**Re: Athlone link road phase 2. Proposed link road joining the Crescent Junction (R915) to Southern Station Road Junction, Athlone, Co. Westmeath – Case Number: ACP-322958-25**

I refer to the request for further information which was issued in respect of this proposed development on 5 January 2026 and I wish to respond as follows (numbering as per the request for further information):

DRAWING No: 120278-501

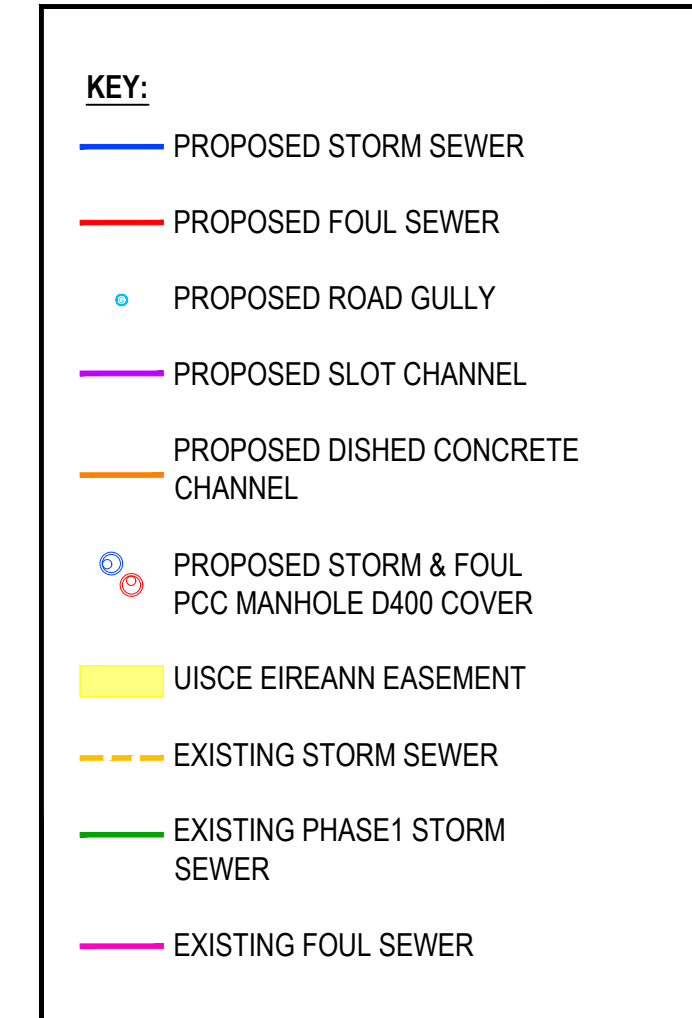
1. *The application Drainage Report refers to shallow channels as draining the western side of the site and the immediate areas to the north and south. This drainage report also states that the application site is on occasion subject to flooding and that despite the sizing the proposed surface water drainage infrastructure to accommodate all storm durations and intensities up to a 1:30 year storm (plus 20% climate change factor), during exceptional events in excess of this water levels may overtop the discharge control (hydrobrake) and result in short-term uncontrolled flows towards the culvert drainage west under Southern Station Road, towards an area that is noted to be prone to flooding under the Shannon Catchment Flood Risk Assessment and Management Study. The Westmeath County Development Plan 2021-2027, the operative statutory plan for this area, includes policy objective CPO 10.106 requiring flood assessments to be carried out for any development proposals within 200m of a watercourse and at risk of flood.*

***The applicant is requested to submit a Site Specific Flood Risk Assessment following the approach set out in “The Planning System and Flood Risk Management Guidelines for Planning Authorities” (2009), including the technical Appendices.***

*Response:* The proposed surface water drainage infrastructure has now been increased to accommodate all storm durations and intensities up to a 1:100 year storm (plus 20% climate change factor). A revised Drainage Report is attached.

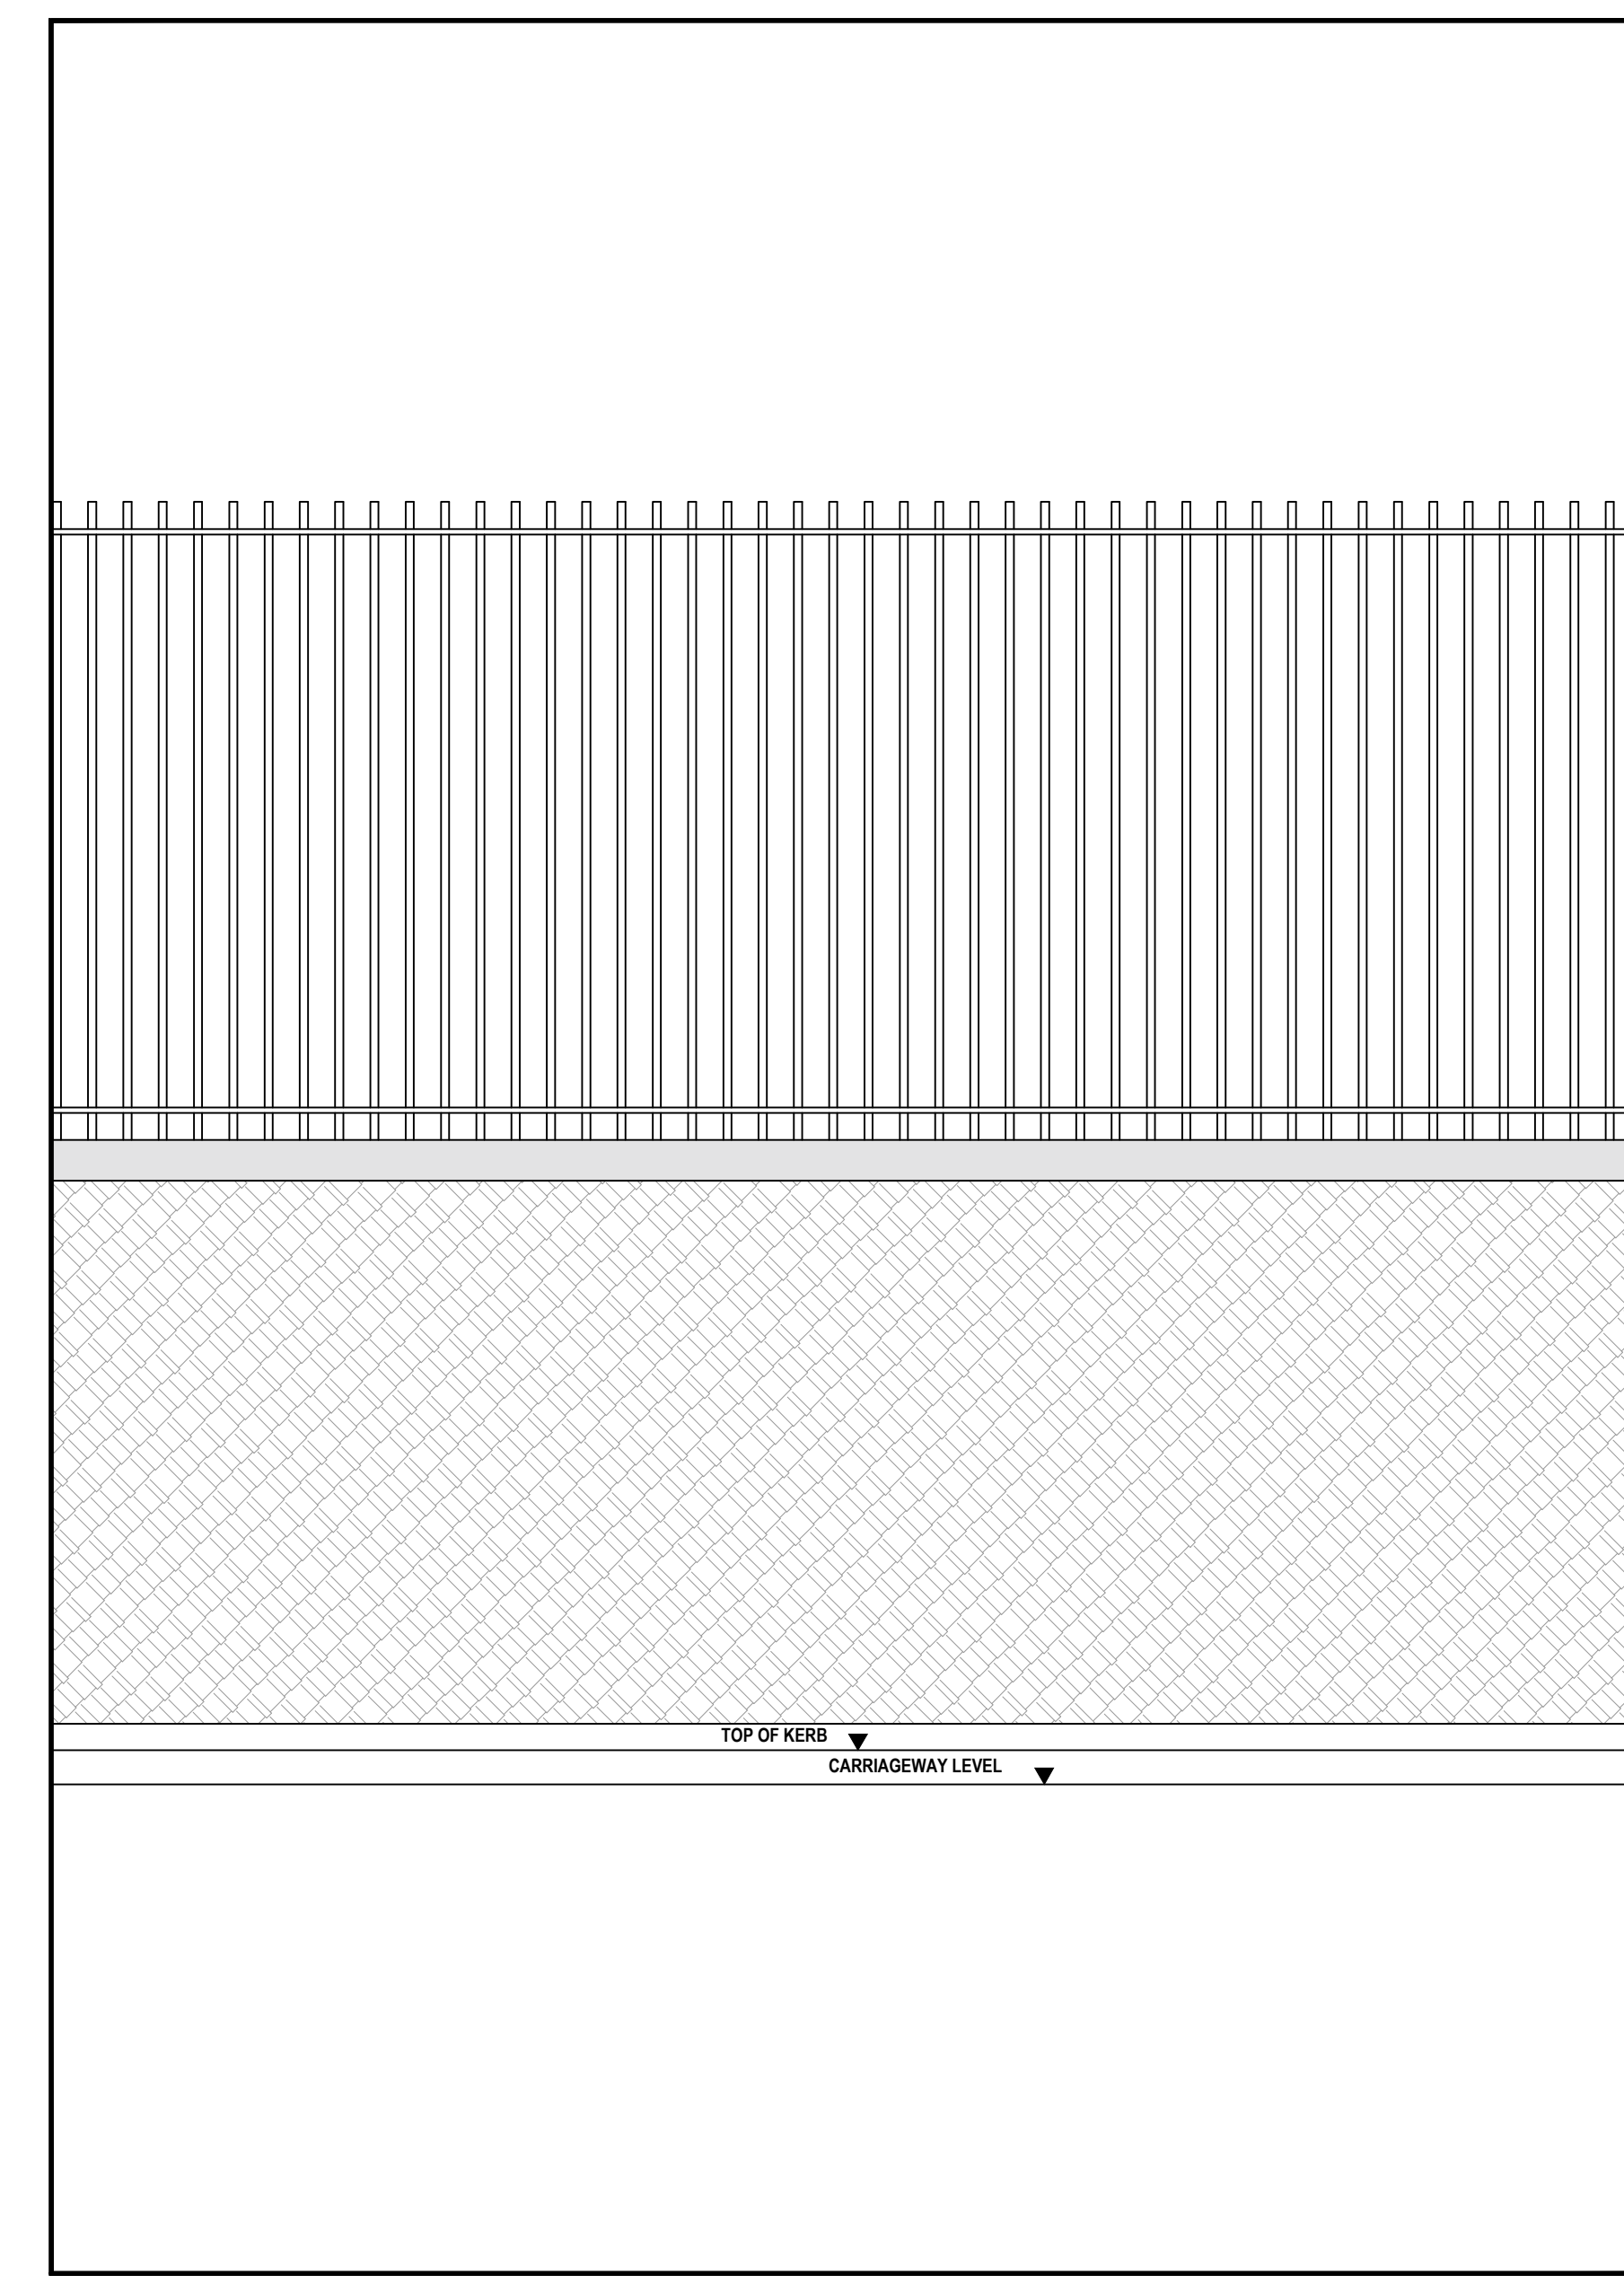
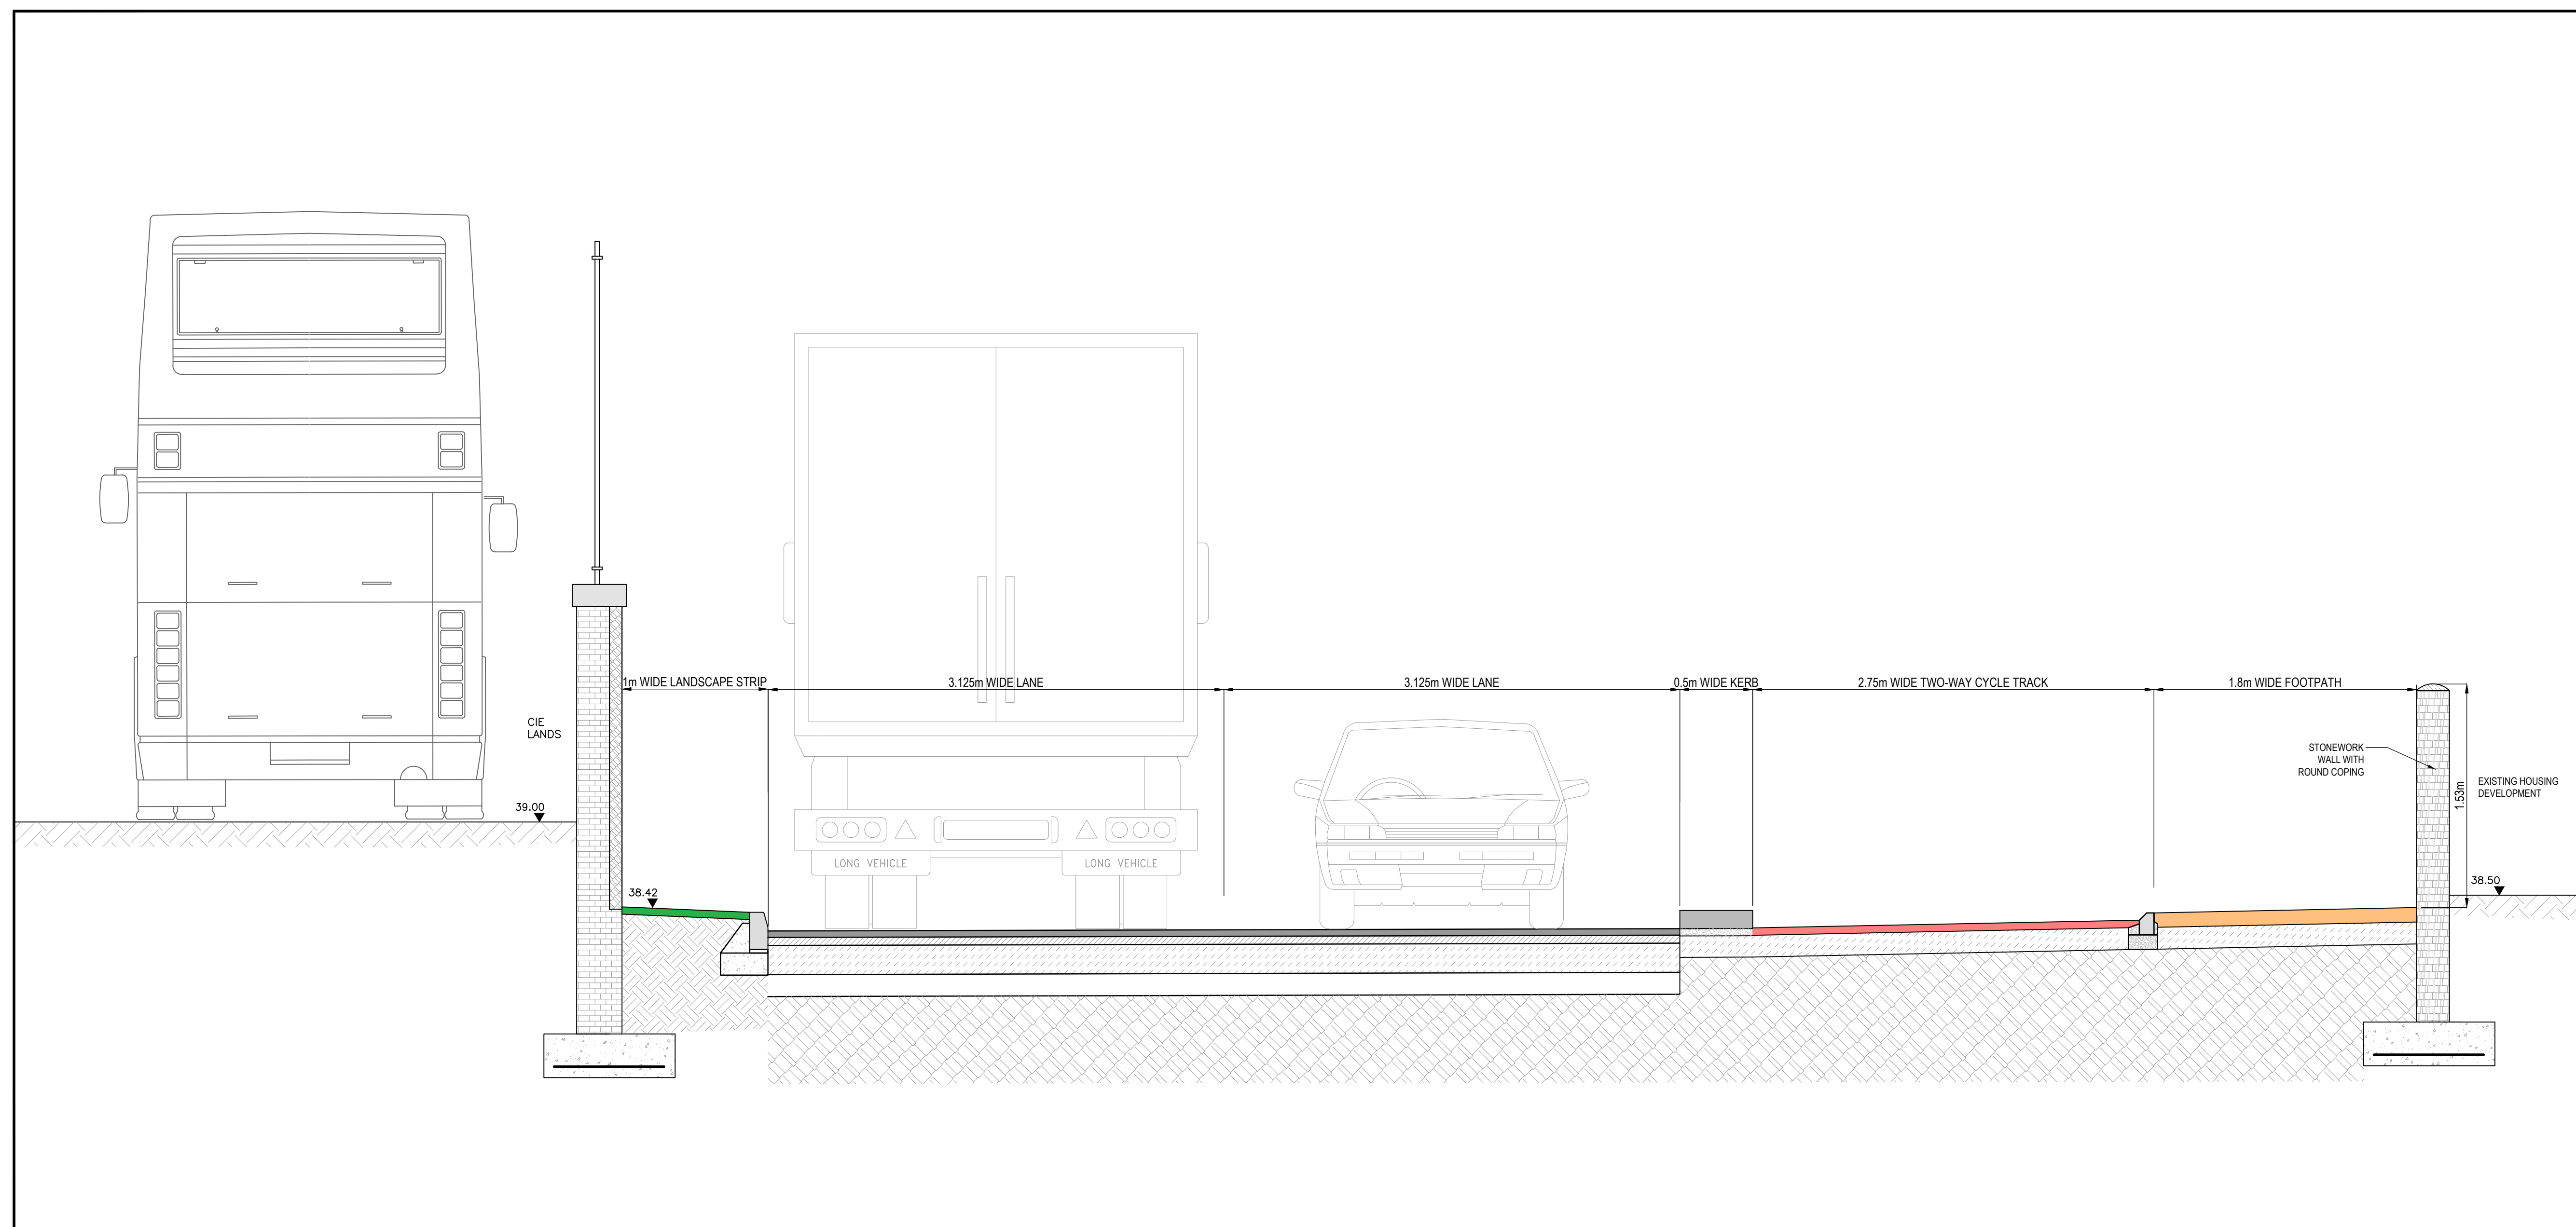
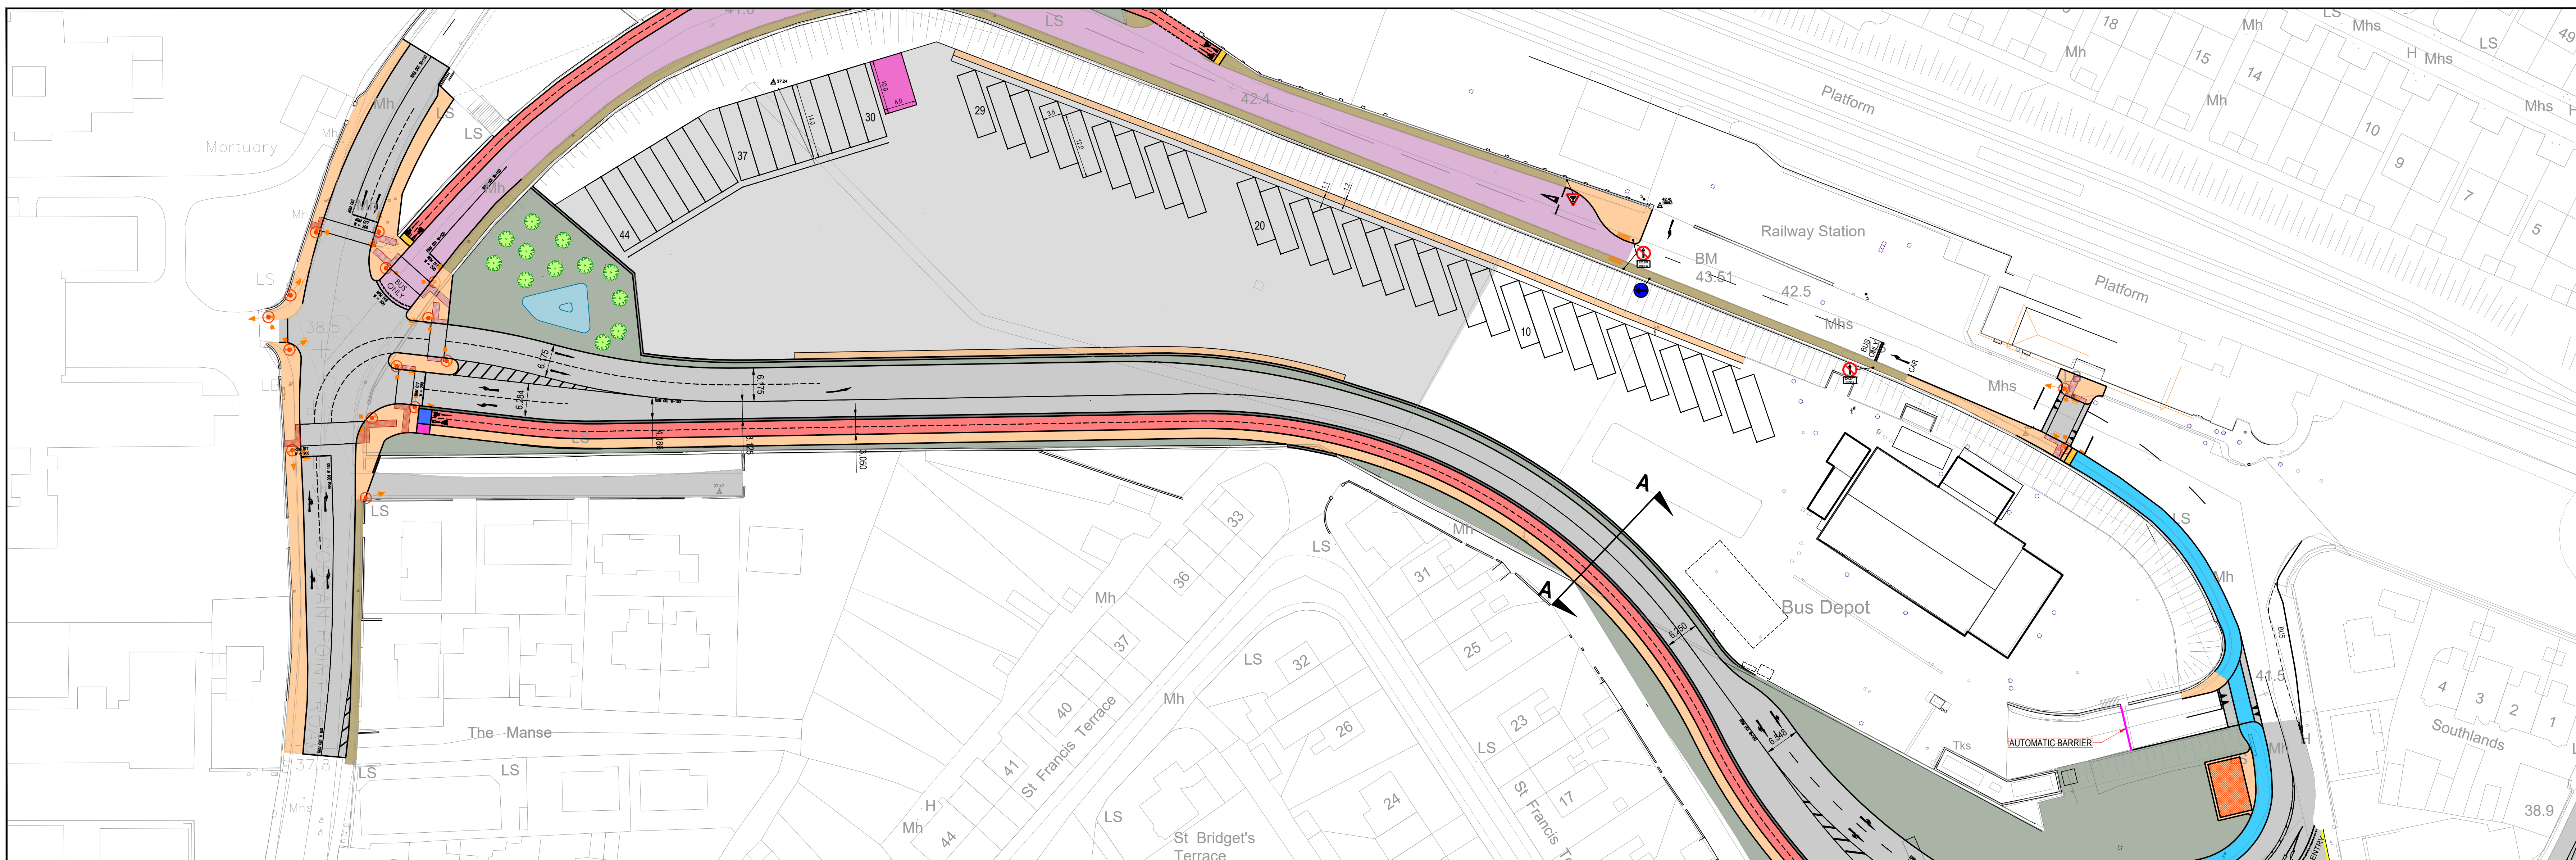
***The applicant is requested to submit revised drawings for this boundary treatment, cognisant of the provisions set out above, including the need for a reduced height to the boundary treatment.***

4. ***The applicant is requested to provide cross-section drawings to a stated metric scale, illustrating the context for the proposed link road and housing along The Manse and St. Francis' Terrace.***

*Response:* The height of the proposed boundary treatment between the proposed link road and the expanded bus depot was sought by CIE / Bus Éireann during initial discussions with them. However, this has now been reduced in agreement with CIE/ Bus Éireann. The reduction in the height is outlined on drawing 120278-725 PL3 Typical Cross Section and is enclosed herewith.

*Response:* Drawing 120278-725 PL3 Typical Cross Section, outlines the proposed development in relation to the housing along The Manse and St. Francis' Terrace and is enclosed herewith.
